From: Laura Gibbons <Laura.Gibbons@arun.gov.uk>
Sent: 15 September 2020 12:14
To: Planning.Responses <Planning.Responses@arun.gov.uk>
Cc: Raymond Cole <Raymond.Cole@arun.gov.uk>
Subject: BE/91/20/DOC- Land West of New Barn Lane

Engineers Comments Regarding Condition 5- Surface Water Drainage

Plans have been submitted for the proposed surface water drainage scheme. The details submitted are insufficient, please can the applicant supply the following information:

TITLE: ON-PLOT PROPOSED DRAINAGE LAYOUT

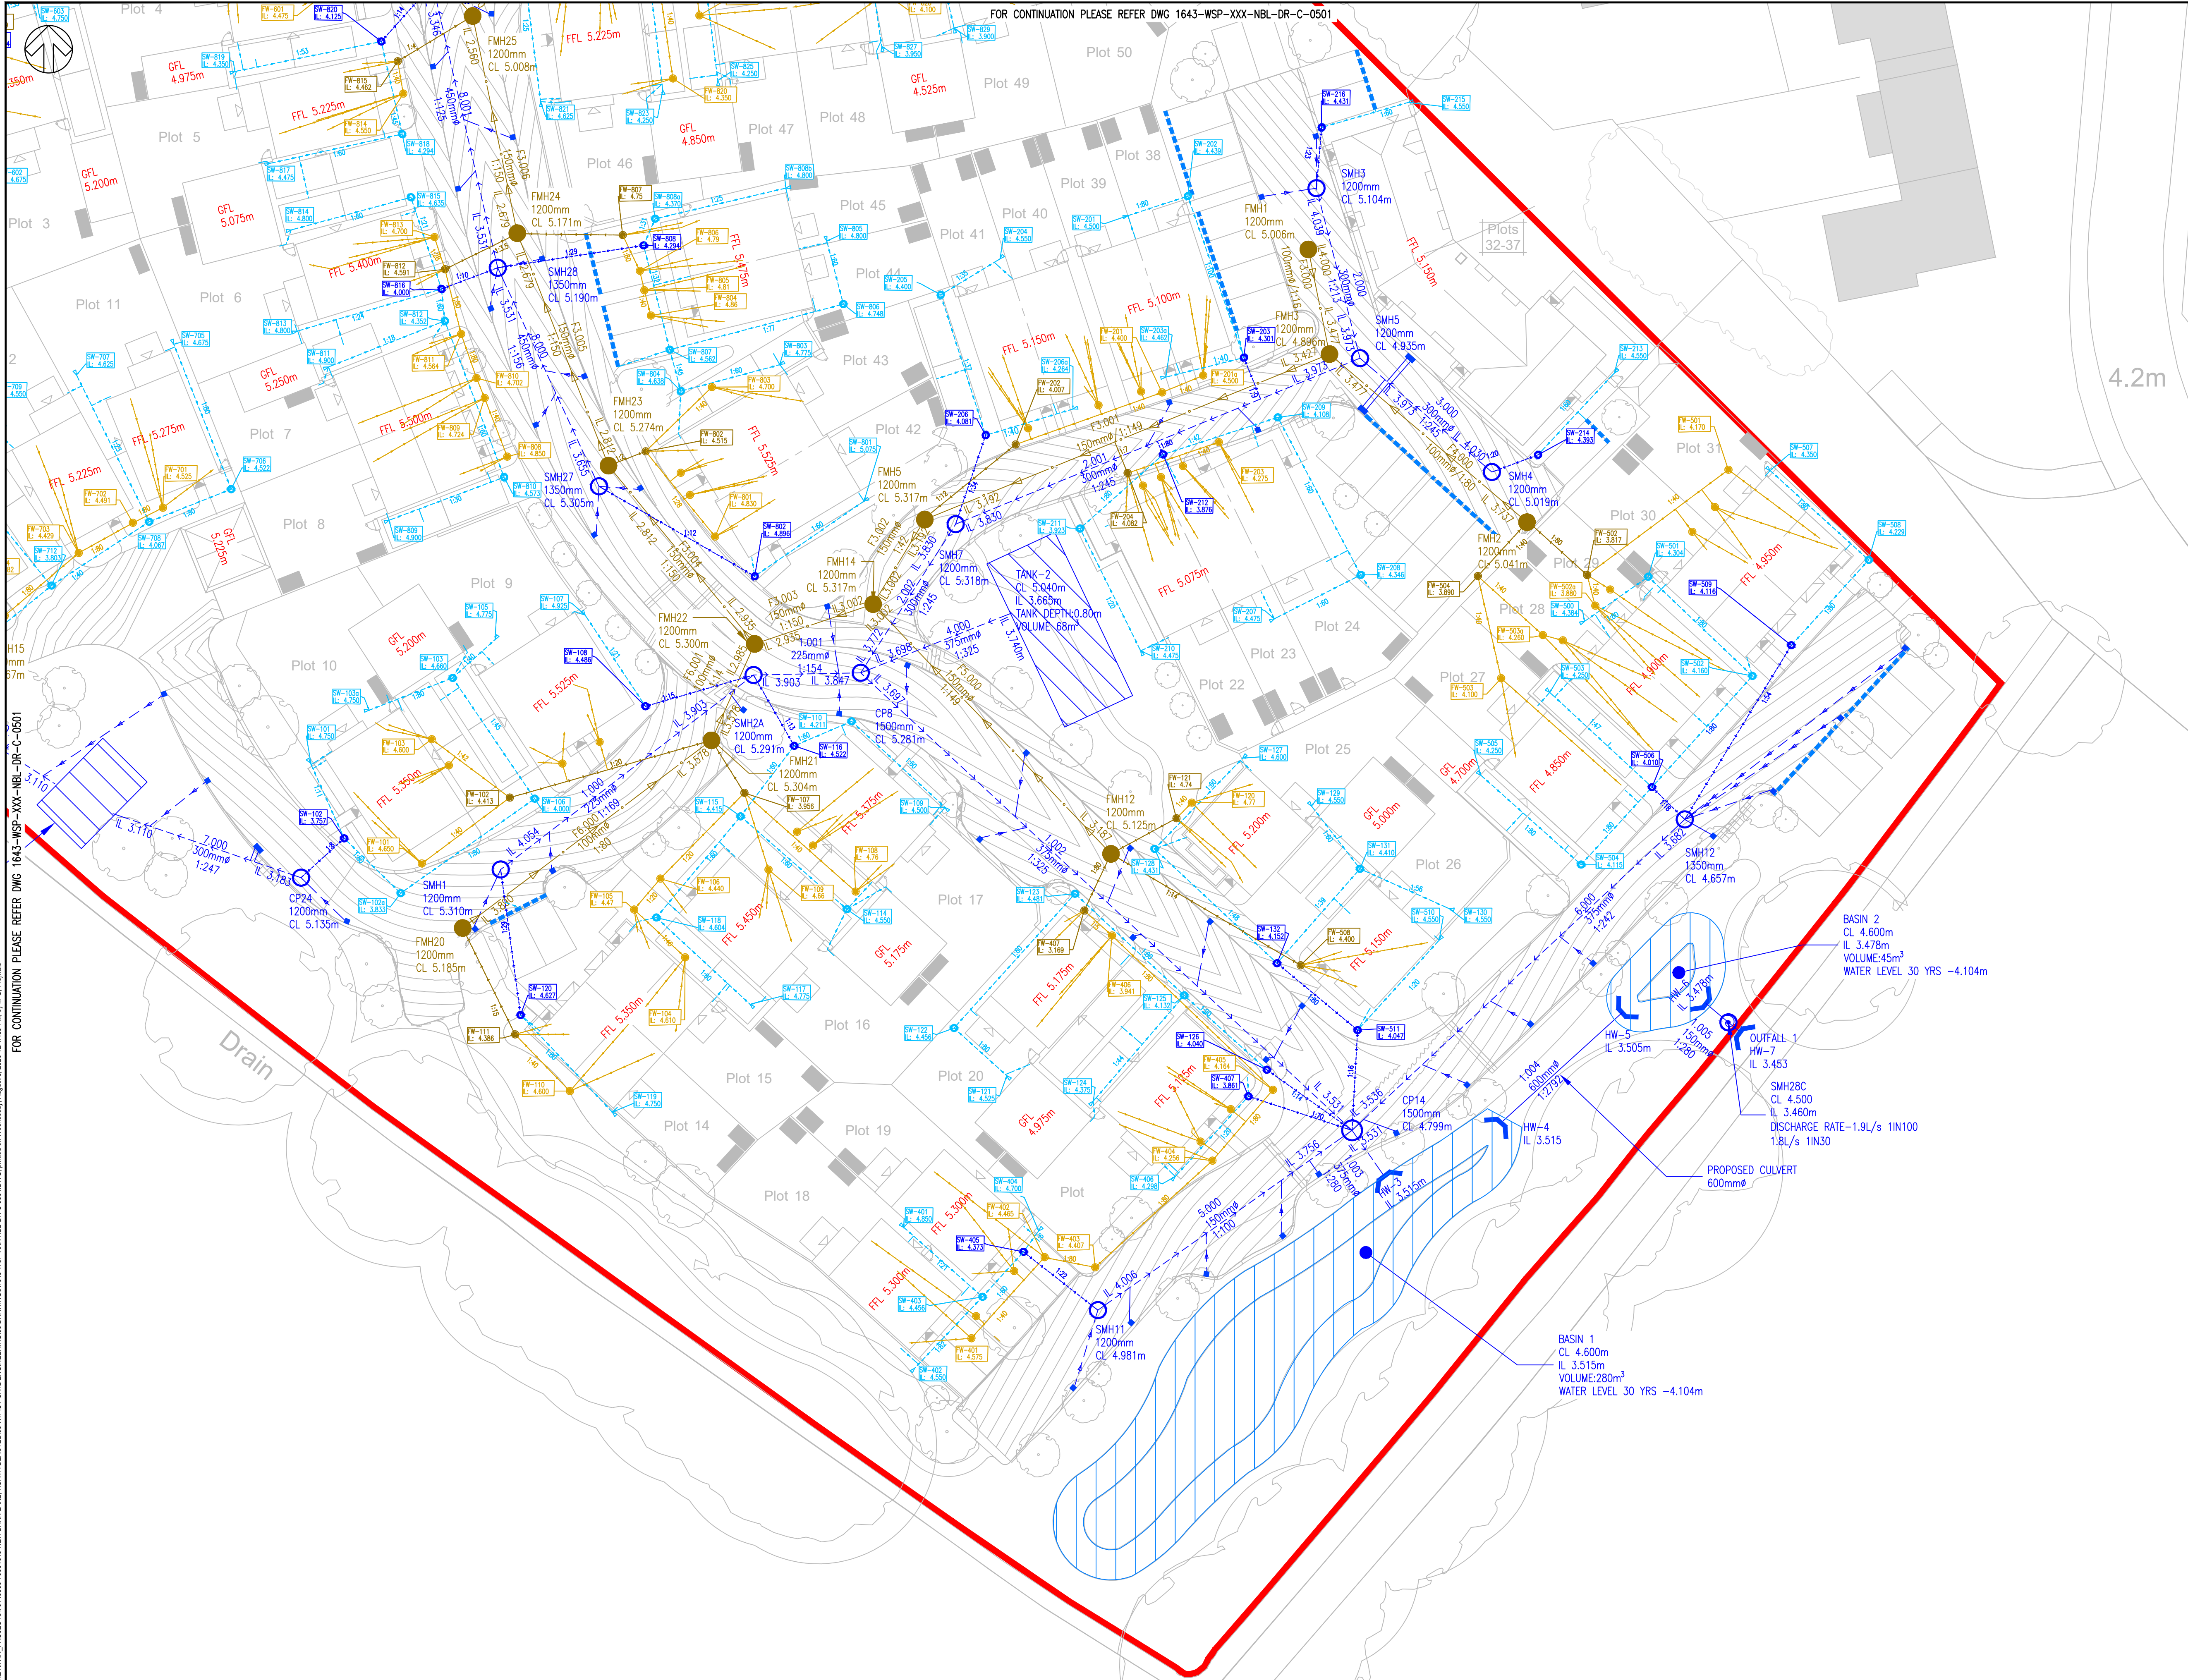
4. Impermeable areas plan. Preferably in dwg format to facilitate paperless review.
5. The proposed discharge rates are very low in some locations. A minimum permissible discharge rate of 2l/s is usually applied across the district because of the increased risk of blockage at lower flows. Please detail proposed aperture sizes so that this can be further reviewed.

13. Details of bed levels of ditches, including invert levels of pipes.
14. A plan showing root potential areas and tanks. There must be no overlap between root potential areas and tanks and basins.

TITLE: ON PLOT HEADWALL STANDARD DETAILS

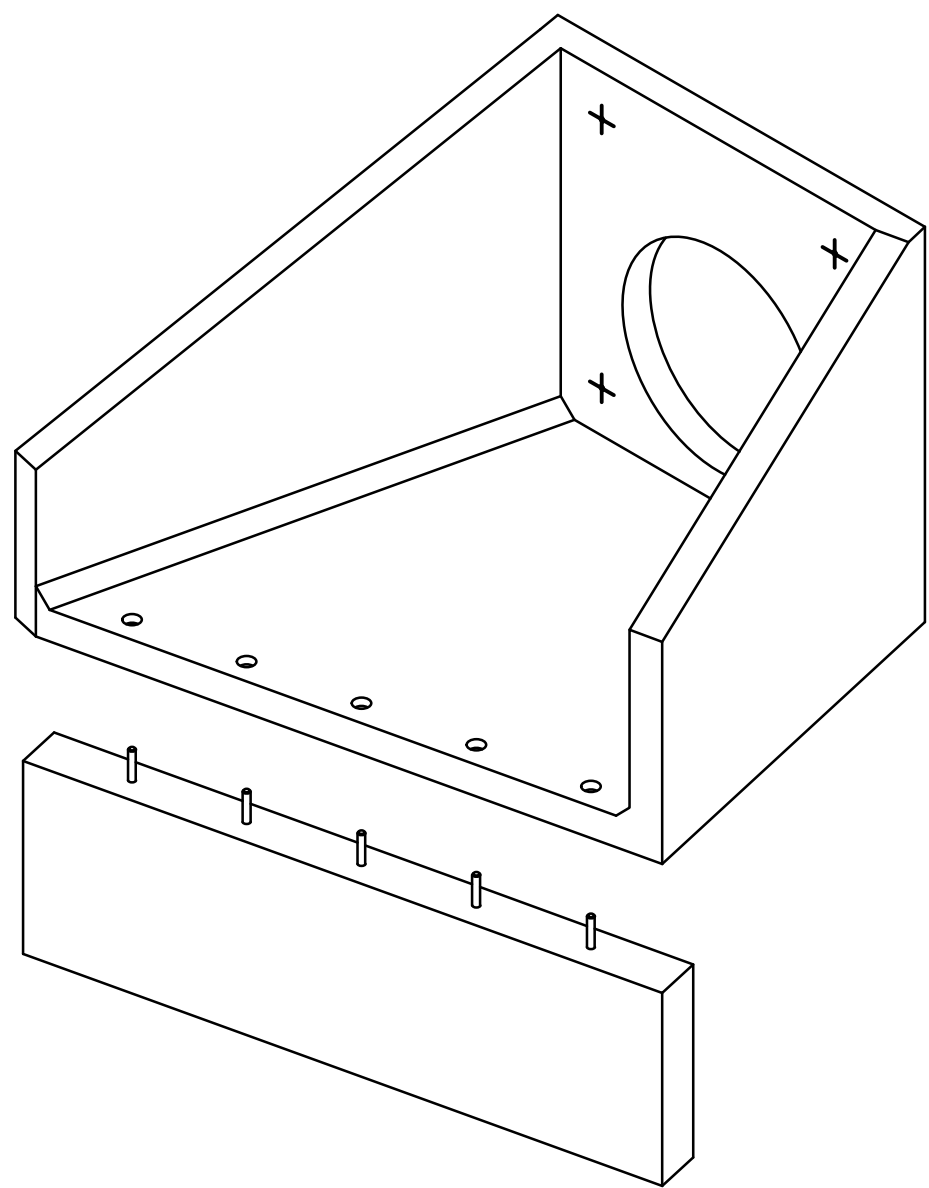
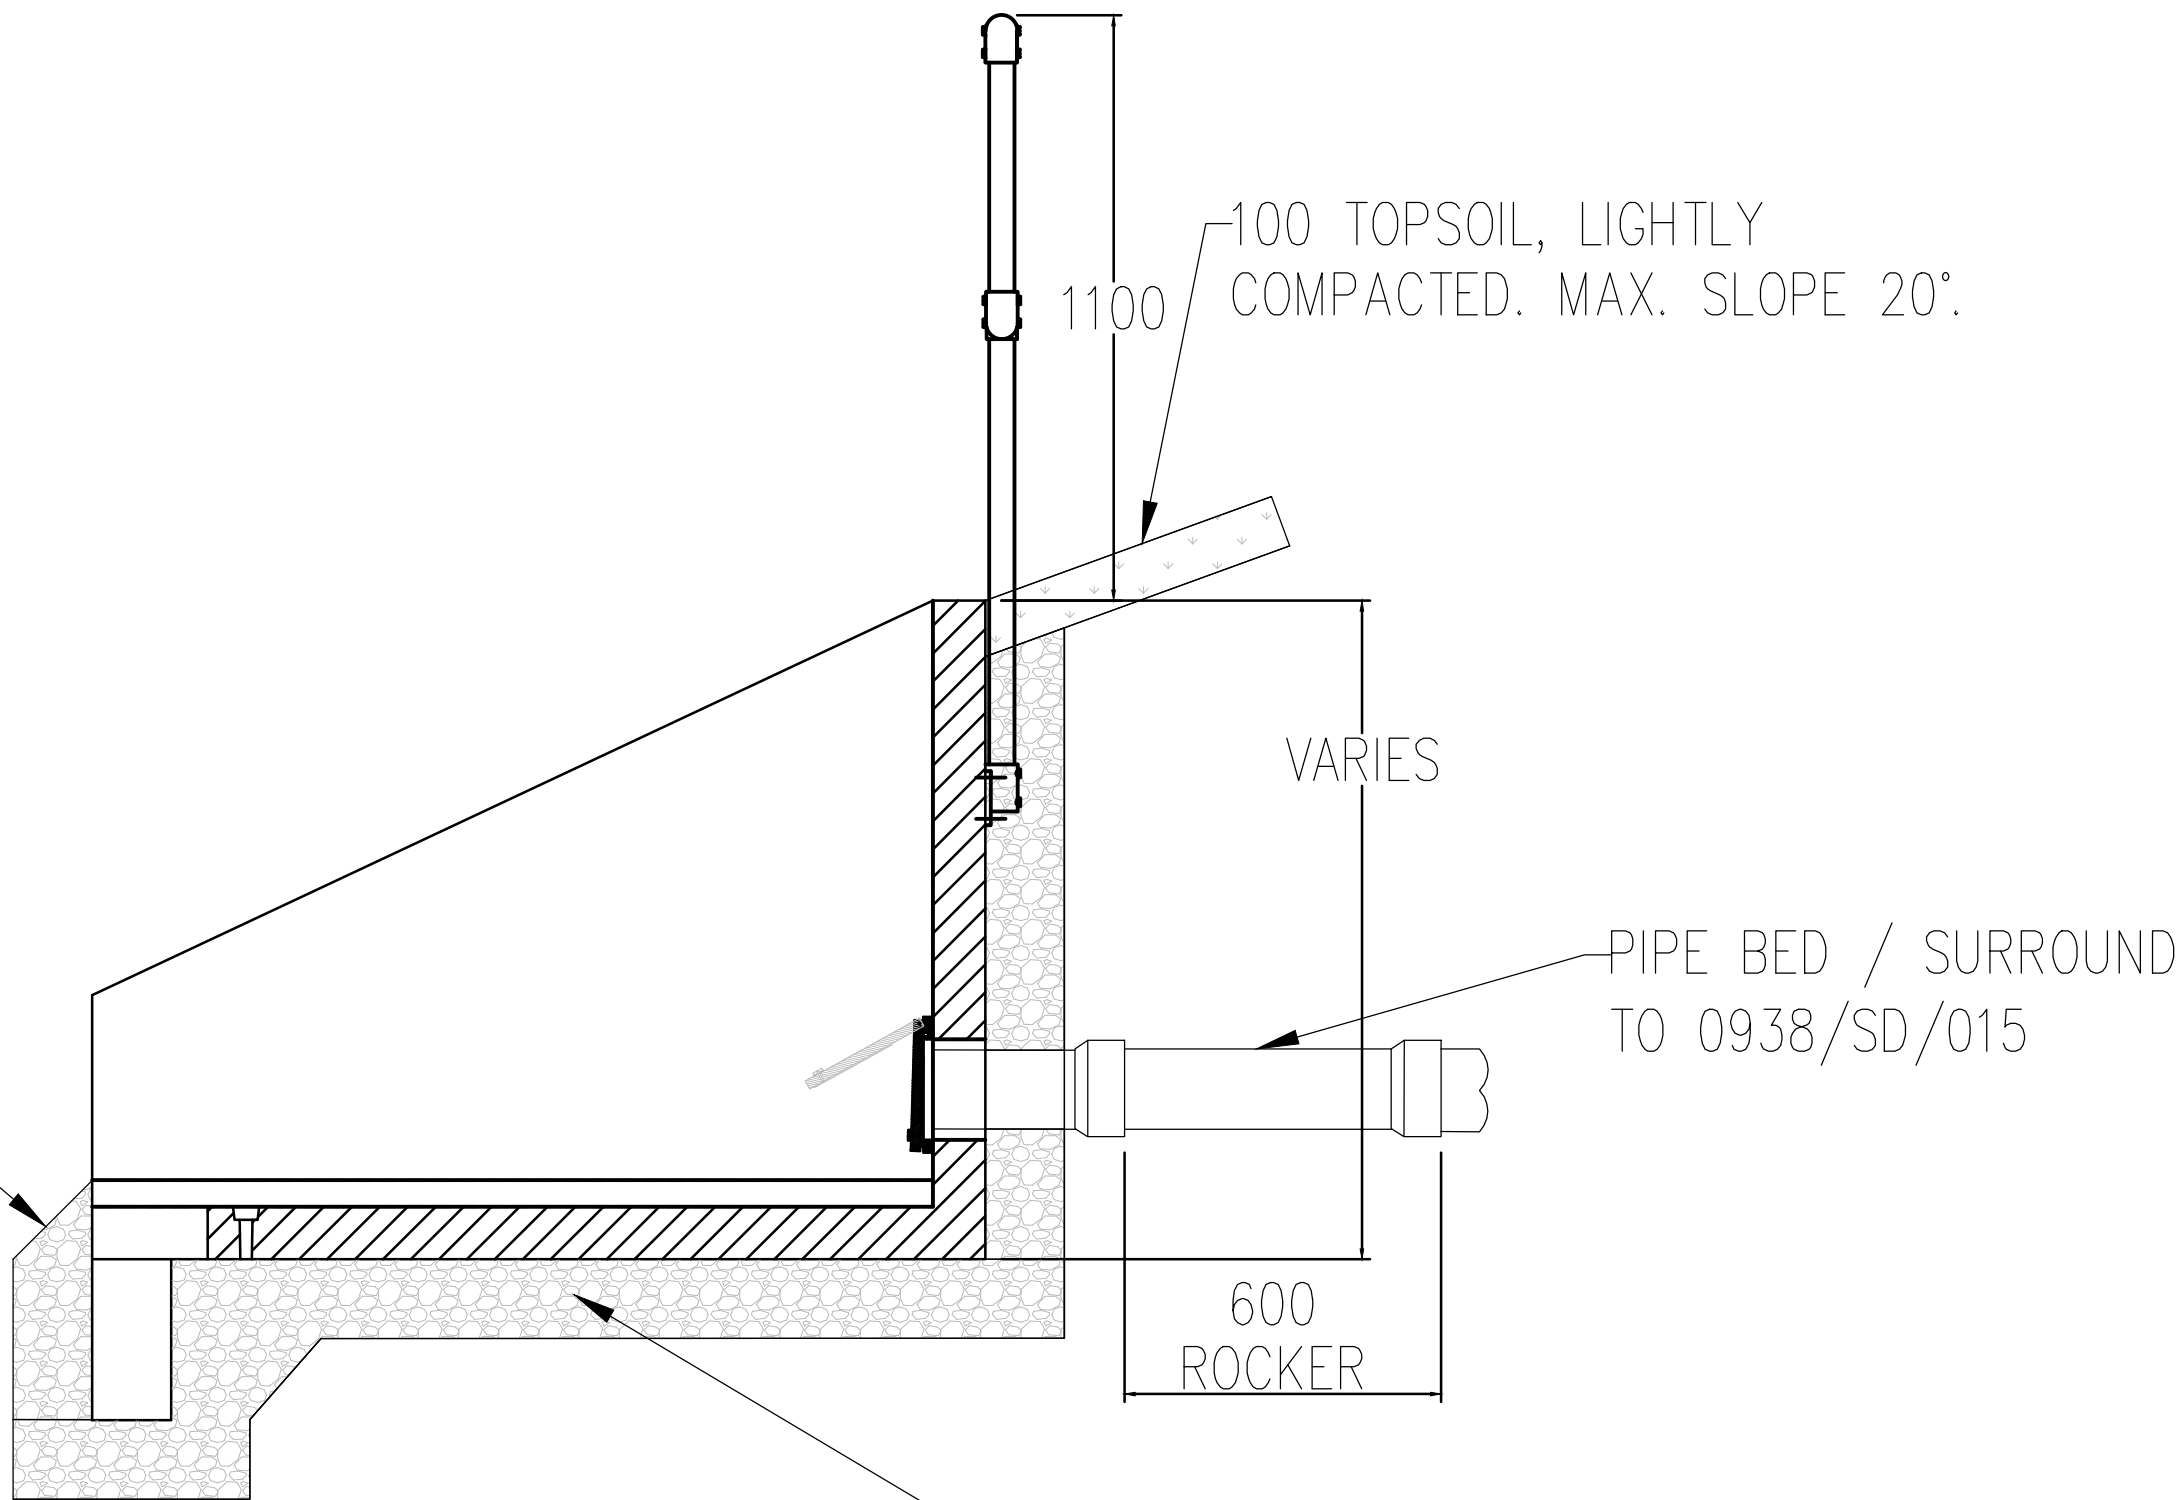
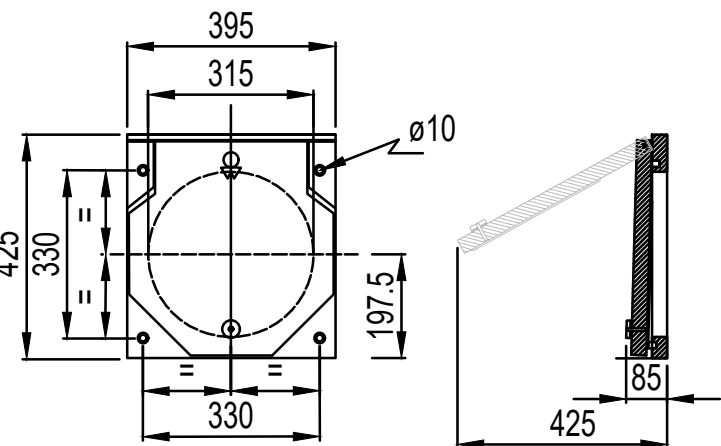
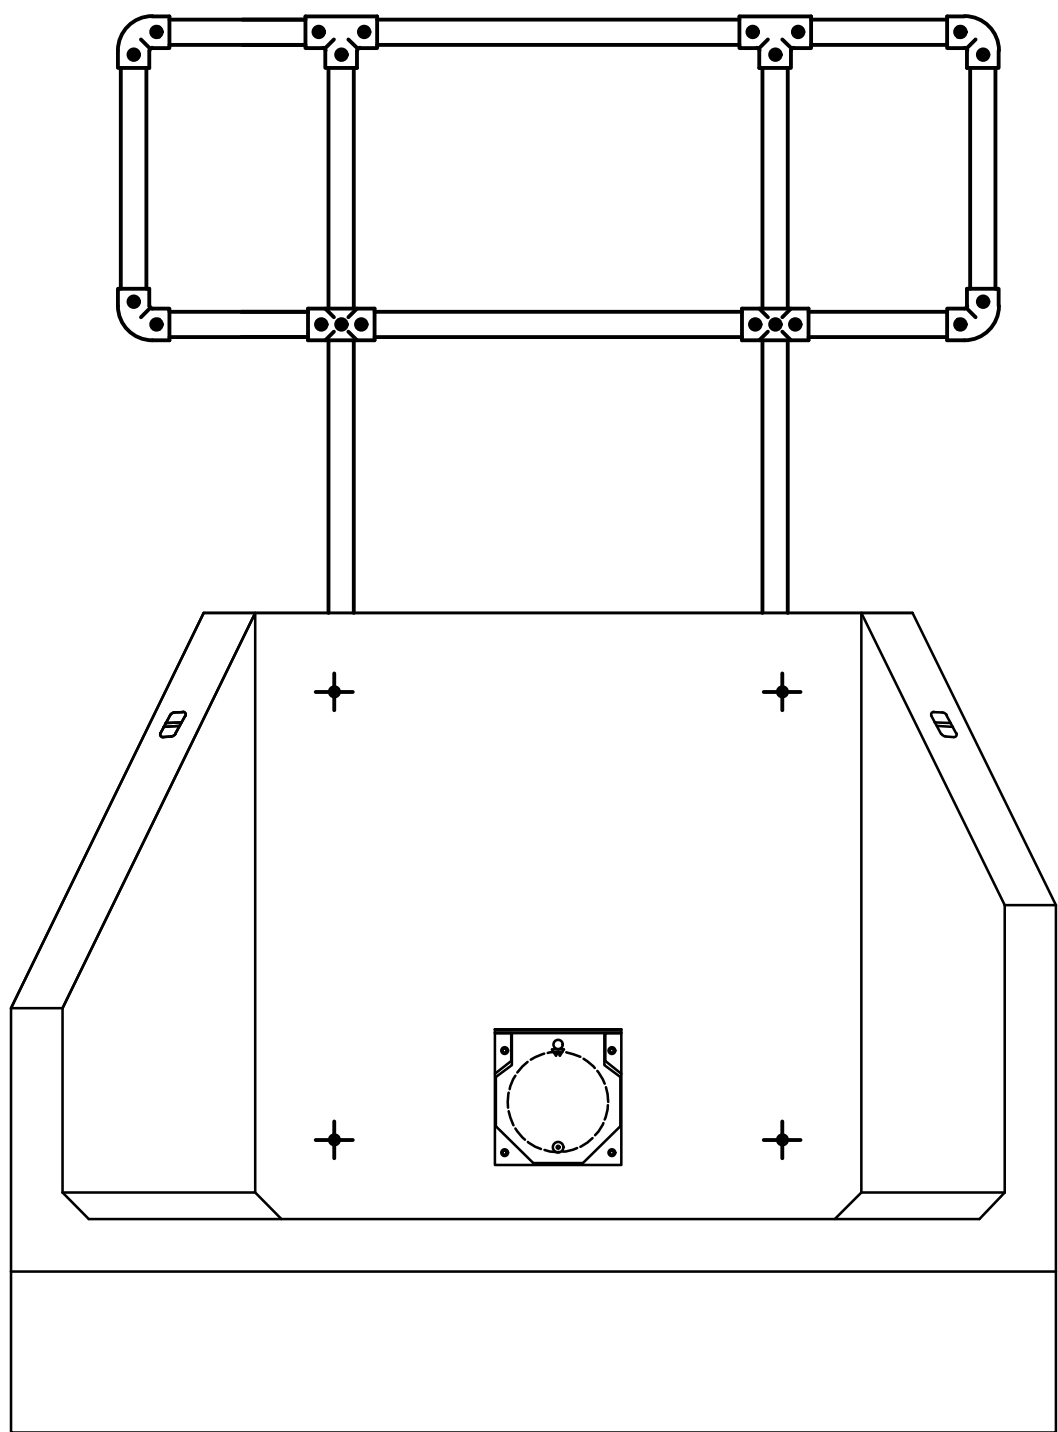
7. Site specific construction detail drawings of attenuation tanks.
8. Site specific construction details of all flow control devices and headwalls.
9. Flotation calculations supporting the design.
